Permit Reviews Harnett County

Permit Number: BCOM2603-0003

Description: **Twice Told Treasures Antique Mall (No Construction)**

Site Address: **3695 US 301 N**

"Recombination Survey For:"
Carlie C. McLamb, Jr.

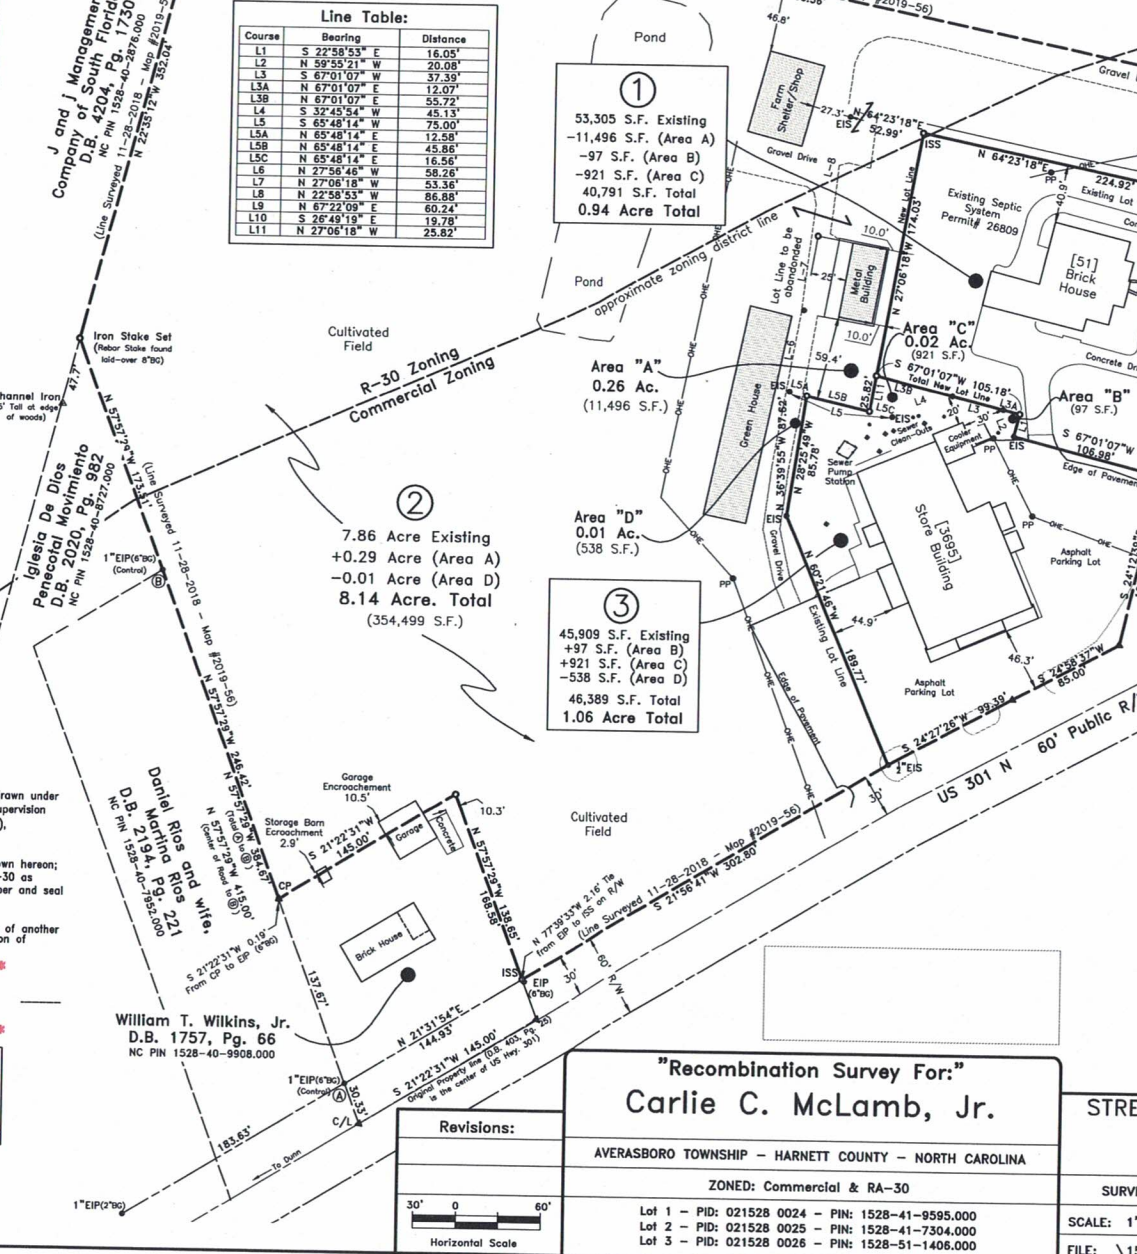
SENT DATE	RETURNED DATE	DUE DATE	TYPE	CONTACT	STATUS	REMARKS
Review Group: 1ST PLAN REVIEW						
3/10/2026		3/24/2026	FIRE MARSHAL	Fire Bucket		
Notes:						
3/13/2026	3/20/2026	3/27/2026	PLANNING	Planning Bucket	DISAPPROVED	
Notes: - show all existing parking spaces. - spaces should measure at least 9' x 18' - parking space lines should be painted						
Review Group: AUTO						
3/10/2026	3/13/2026		COMMERCIAL INTAKE	CP Bucket	APPROVED	
Notes:						
3/10/2026	3/16/2026	3/24/2026	COMMERCIAL BUILDING REVIEW	Brad Sutton	APPROVED	
Notes: See all notes on approved plan
